re: Geotechnical Recommendations – Grading Plan and Site Servicing Plan Review
Proposed Multi-Storey Building
1184, 1188, and 1196 Cummings Avenue – Ottawa, ON
to: TCU Development – Mr. Dylan Desjardins – d.desjardins@tcudevcorp.com
date: September 18, 2023
file: PG6604-MEMO.02

Paterson reviewed the following grading plan prepared by Stantec Consultant Ltd. regarding the aforementioned site:

- Project No. 160401787 - Drawing No. GP-1 – REV #3 – Site Grading Plan – dated August 30, 2023.

- Project No. 160401787 - Drawing No. SSP-1 – REV #3 – Site Servicing Plan – dated August 30, 2023.

SITE GRADING PLAN

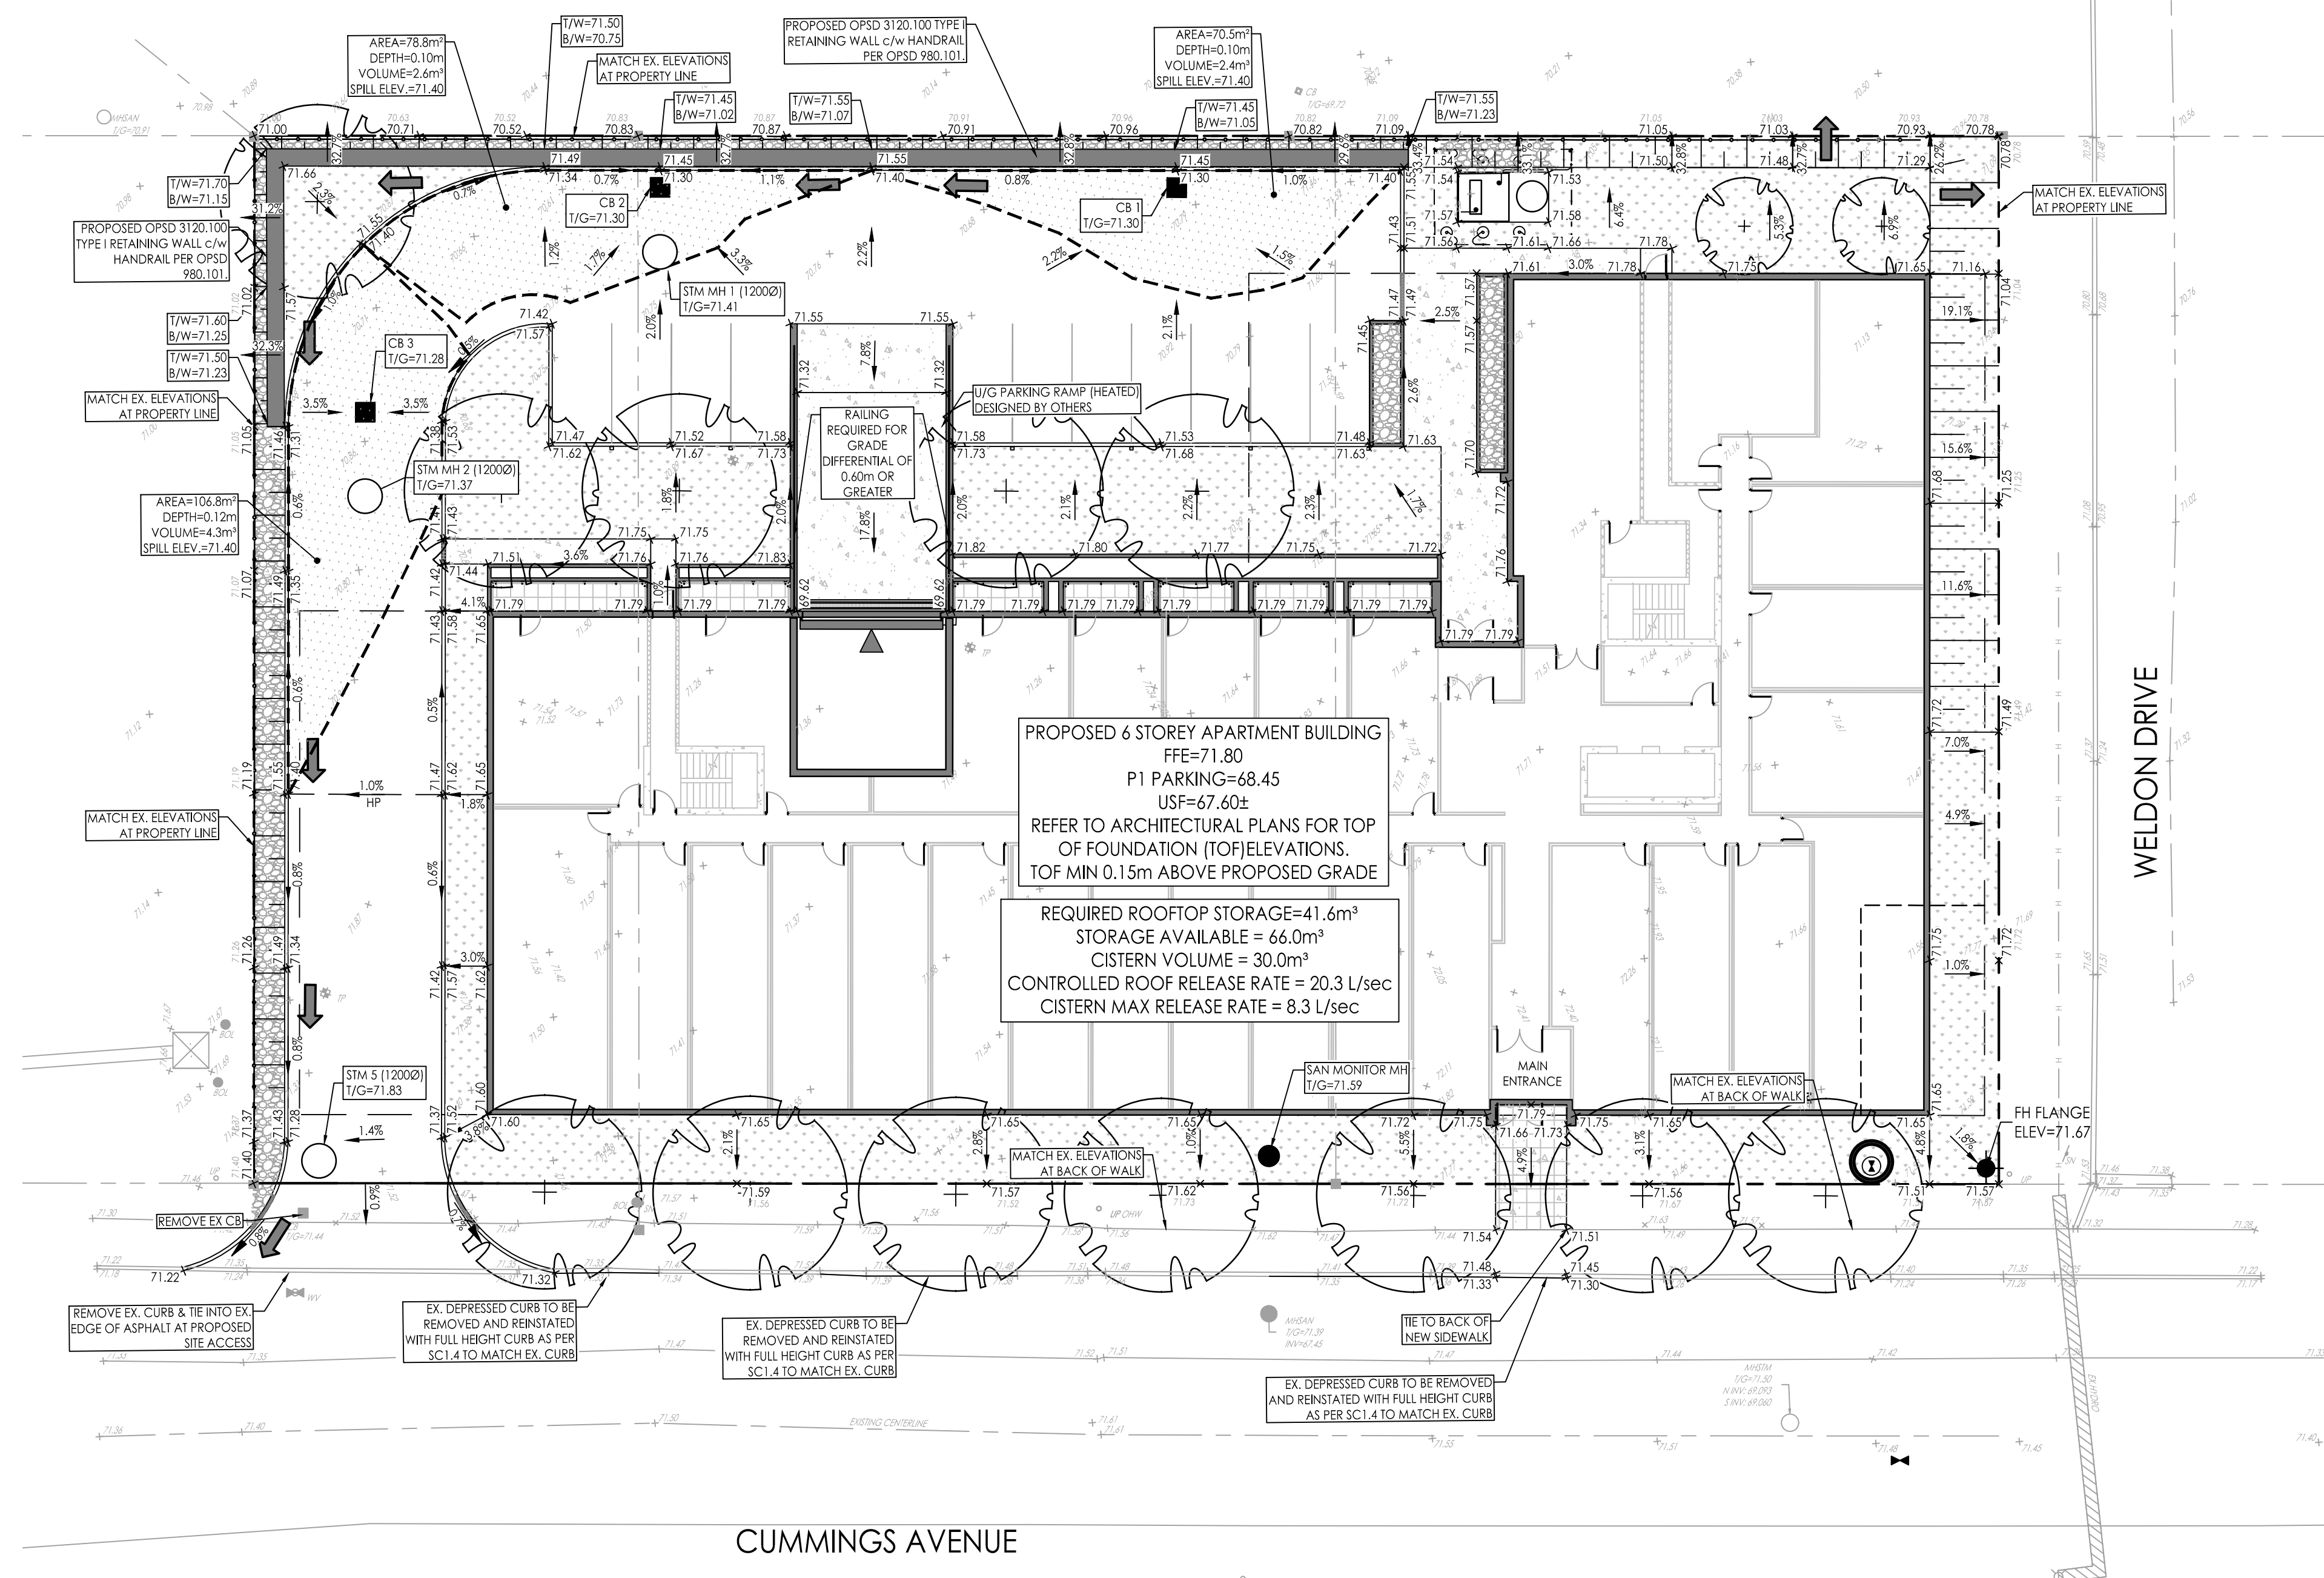
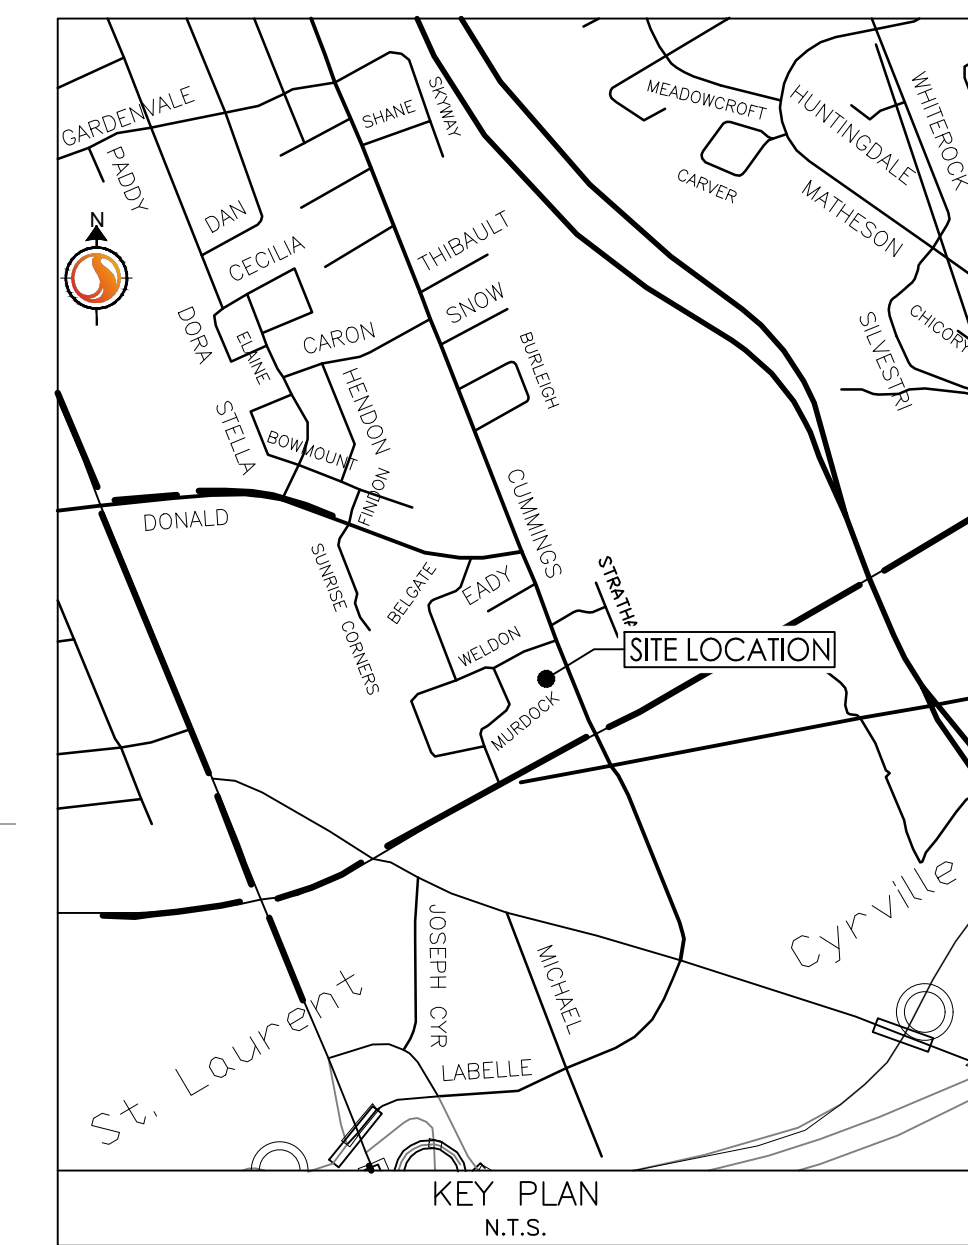
Based on our review of the above noted drawing, it is understood that the finish floor elevation for the ground floor will be at geodetic elevation 71.8 m and that the proposed USF will be at geodetic elevation 67.9 m. Based on that, the available soil cover of 3.9m is sufficient to protect the footings against frost action. It is further understood that the anticipated excavation depth is approximately 3.9 m below proposed finish grade level. Furthermore, it is understood that the available horizontal setback between the proposed foundation wall and property limit is greater than 4m except for the north and east sides where the available horizontal setback is approximately 3.0m. Therefore, a temporary shoring system will be required to support the overburden material along the north and east sides during excavation. The shoring system may consist of soldier pile and lagging or interlocking sheet piles with tiebacks. The design of the shoring system should be completed by a specialized consultant, in accordance with the geotechnical information provided under section 6.3 of the aforementioned geotechnical investigation report.

Based on our review, the proposed grading at the subject site is considered acceptable, from a geotechnical perspective.

Project No.	Scale	Sheet	Revision
160401787	1:200	2 of 7	5
Drawing No.	Revision		PLAN # 19081
<b>SSP-1</b>	2 of 7		<b>5</b>

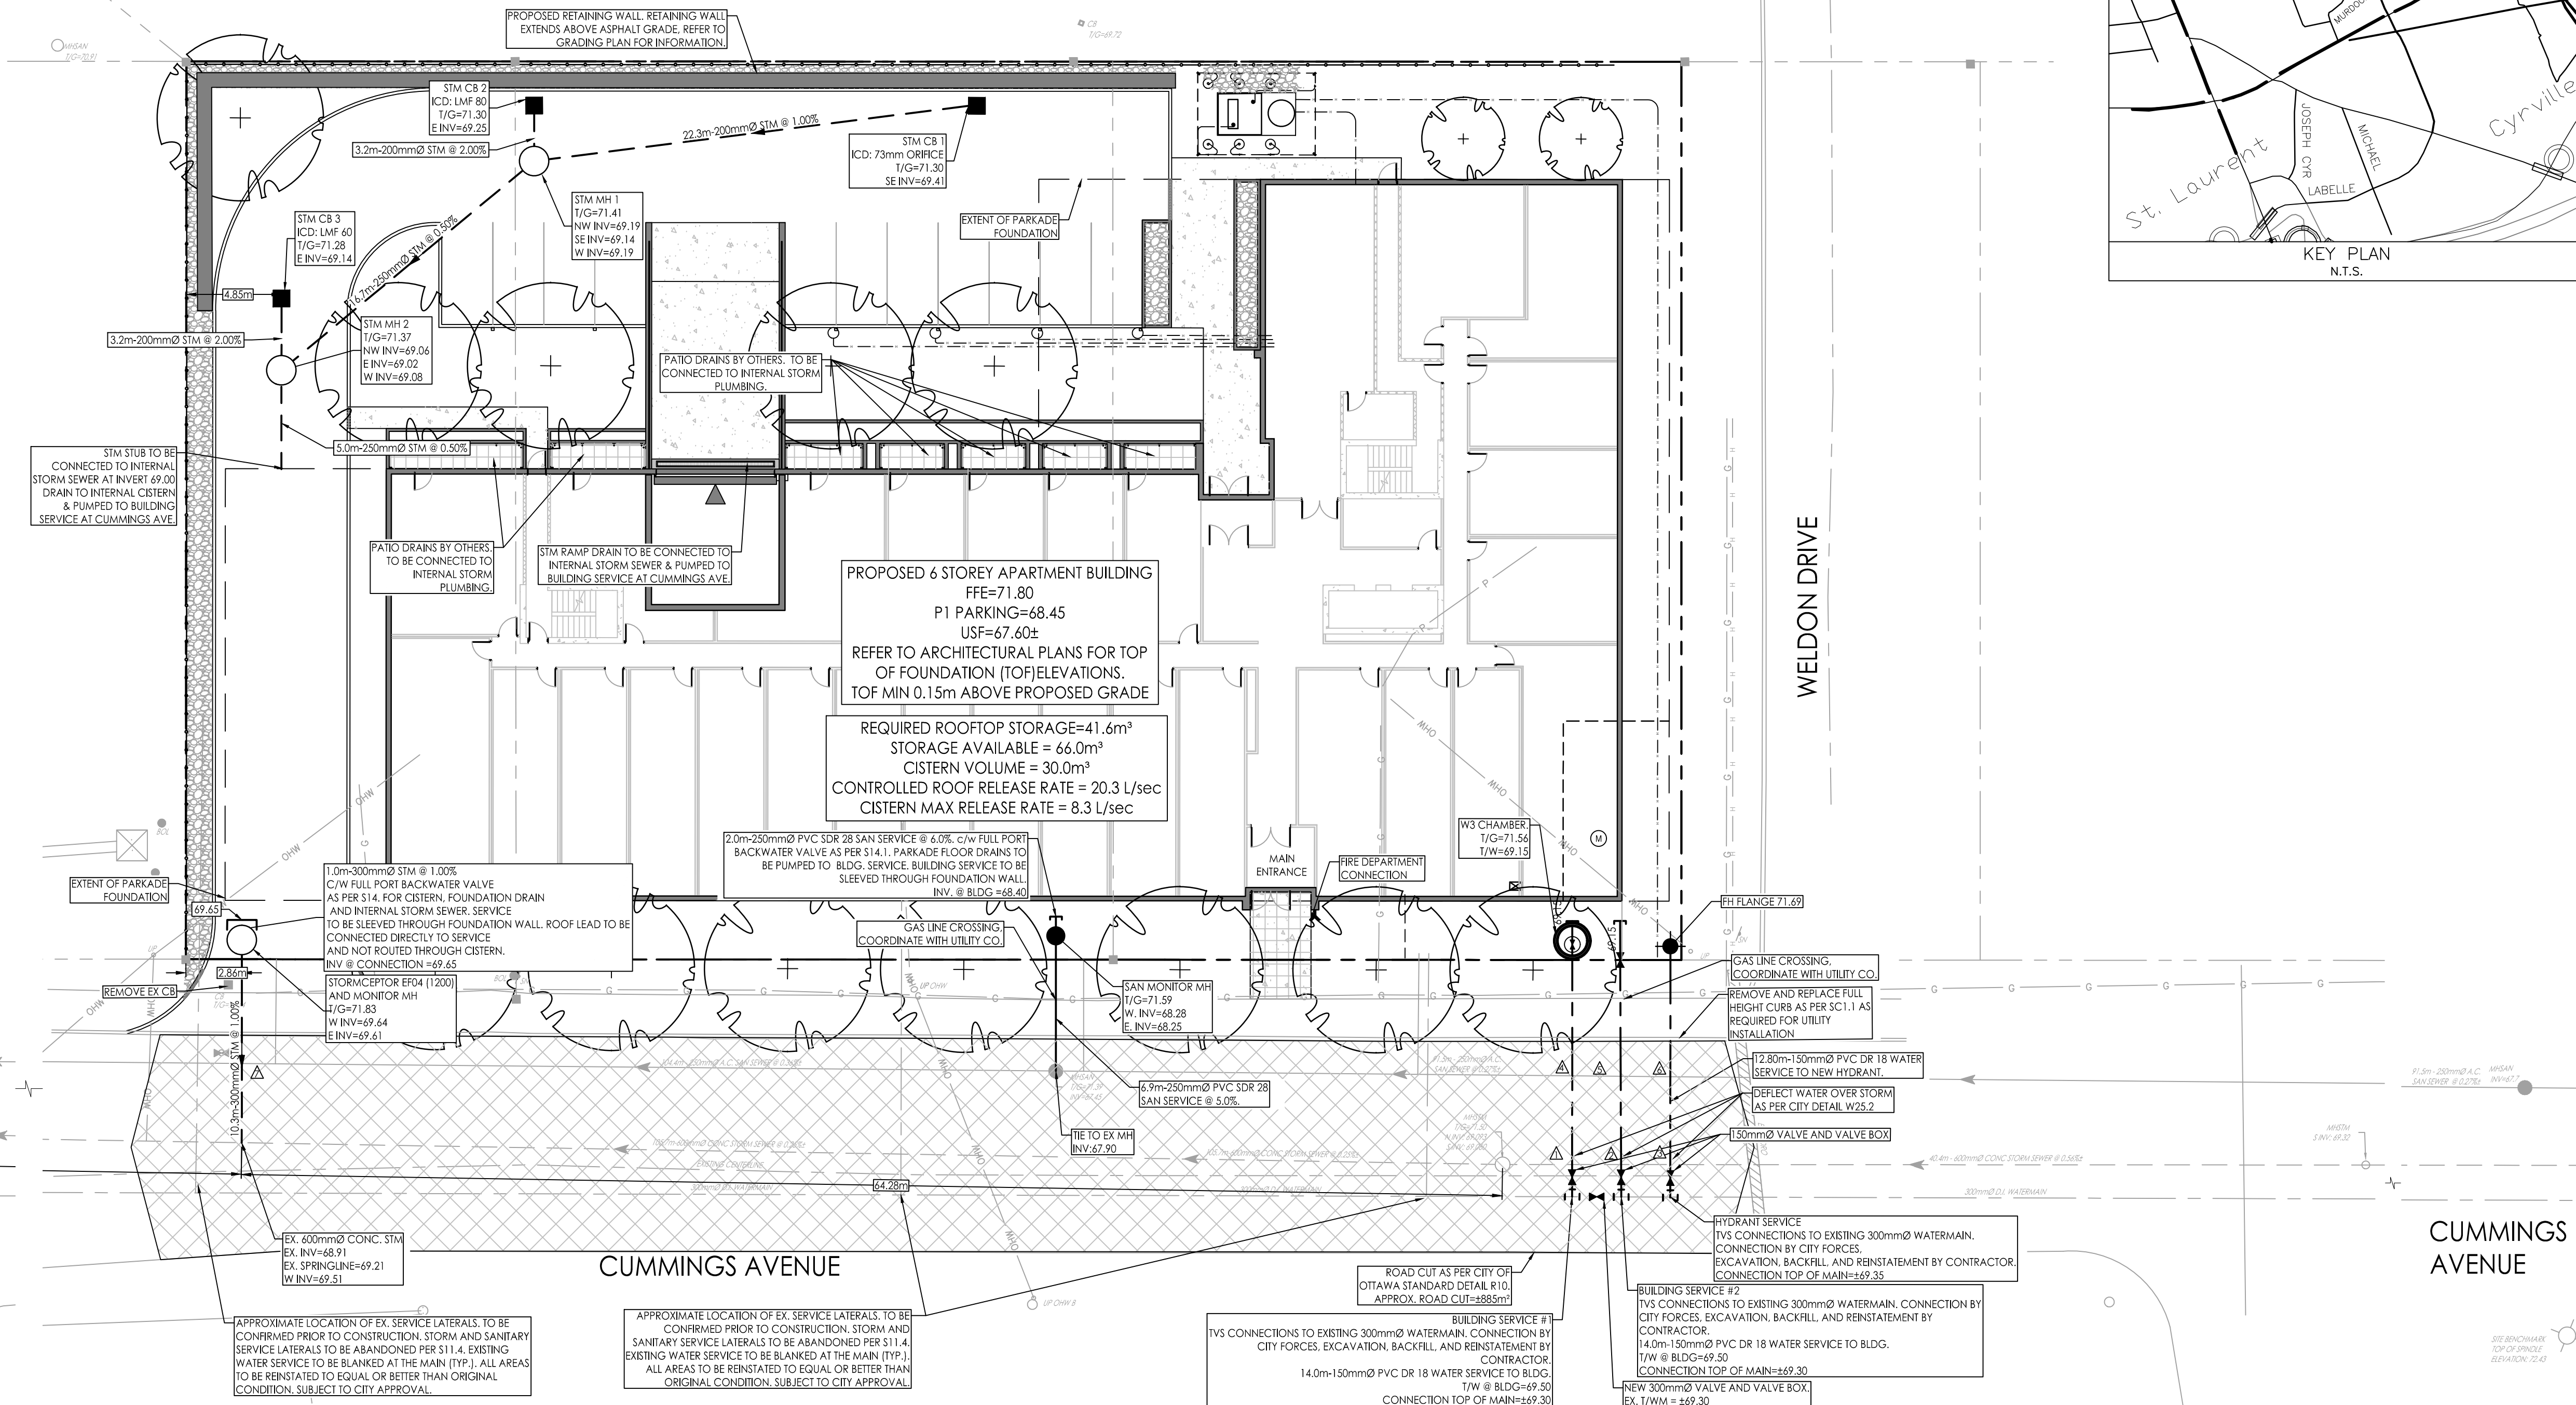
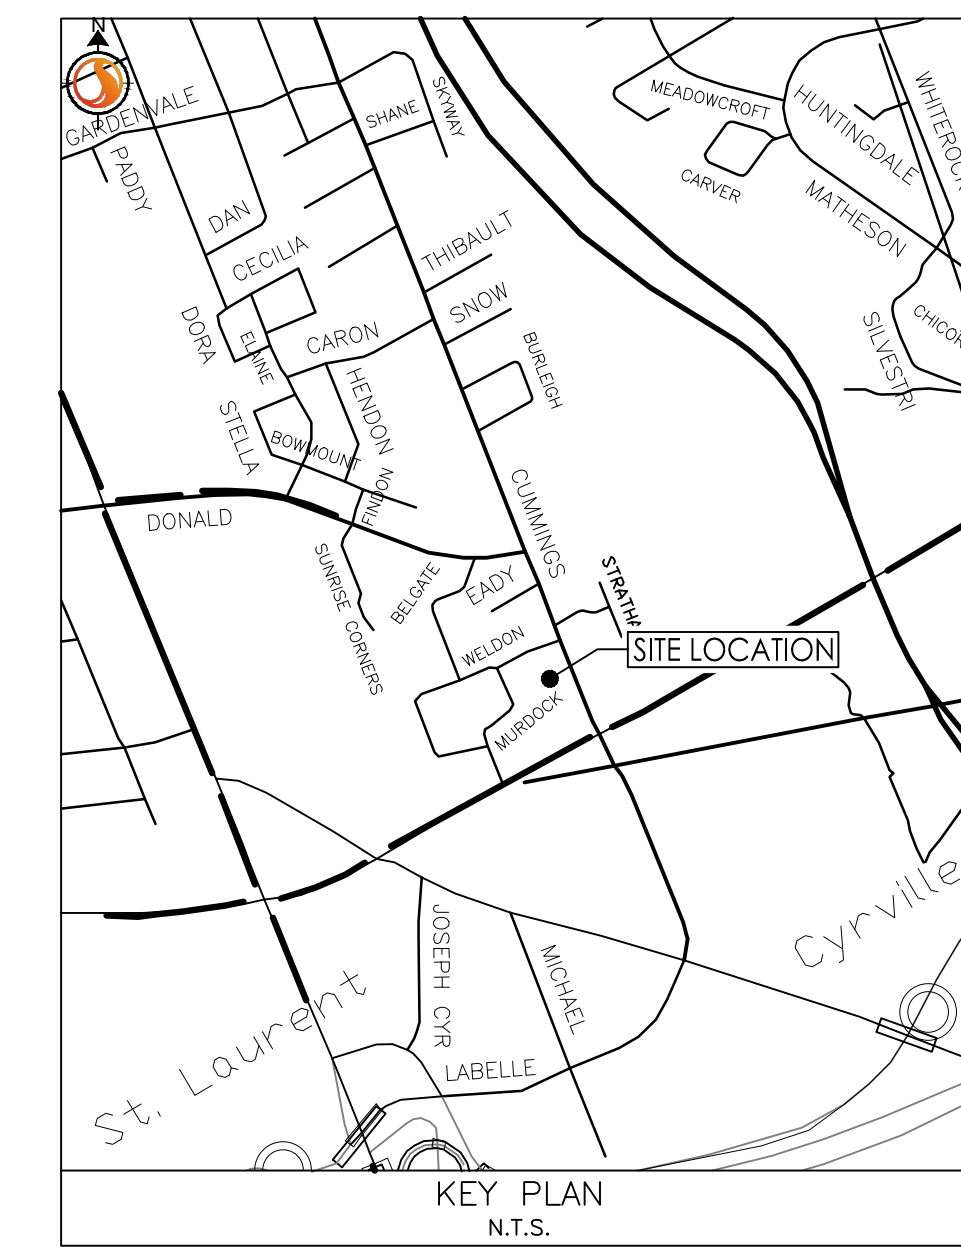
Based on our review, the invert elevations for all service pipes entering the stormwater and sanitary manhole structures throughout the subject site were observed to be located below the frost zone (approximately 1.8m below finish ground surface).

Manhole I.d.	Top of Grate Elevation (m)	Highest Invert Elevation (m)	Minimum Soil cover Present (m)	Pipe Bedding Subgrade Depth (m)
STM CB 1	71.30	69.00	2.30	2.45
STM CB 3	71.28	68.96	2.32	2.47
STM CB 13	71.30	69.06	2.24	2.39
STM MH 2	71.41	69.00	2.41	2.56
STM MH 3	71.37	68.63	2.74	2.89
STORMCEPTOR EF04	71.45	69.64	1.81	1.96
SAN MONITOR MH	71.50	68.28	3.22	3.37

In addition, all service pipes were noted to be outside the lateral support zone of the proposed footings. Therefore, and based on our review and the summary provided in Table 1, the proposed invert levels for the storm and sanitary pipes are considered acceptable from a geotechnical perspective.

Based on our review of the proposed site servicing plan, it is understood that the invert level for the proposed 300mm storm pipe ranges between geodetic elevation 69.61 to 69.51m. It is further understood that the invert level for the existing 250mm AC sanitary sewer is at geodetic elevation 67.70m. Therefore, the vertical separation between the proposed storm pipe and existing sanitary pipe is approximately 1.56m. Based on our review, the proposed vertical separation between the proposed storm pipe and the existing sanitary sewer is considered acceptable from a geotechnical perspective.

It is understood that three proposed 300mm watermain laterals will be crossing over the existing 600mm concrete storm sewer along Cummings Avenue. Based on our review of the site servicing plans, it is understood that the invert levels for the proposed watermain laterals and the existing 600mm concrete storm sewer are at approximate geodetic elevations 69.30m and 69.69m respectively. However, it is understood that the proposed watermain laterals will be deflected over the existing storm sewer as per the City Detail W25.2.

It should be noted that an existing gas pipe was observed to be running along Cummings Avenue. However, the invert level for the existing gas line is not known. The location of the gas main should be coordinated prior to construction to avoid any conflicts with the proposed watermain laterals.
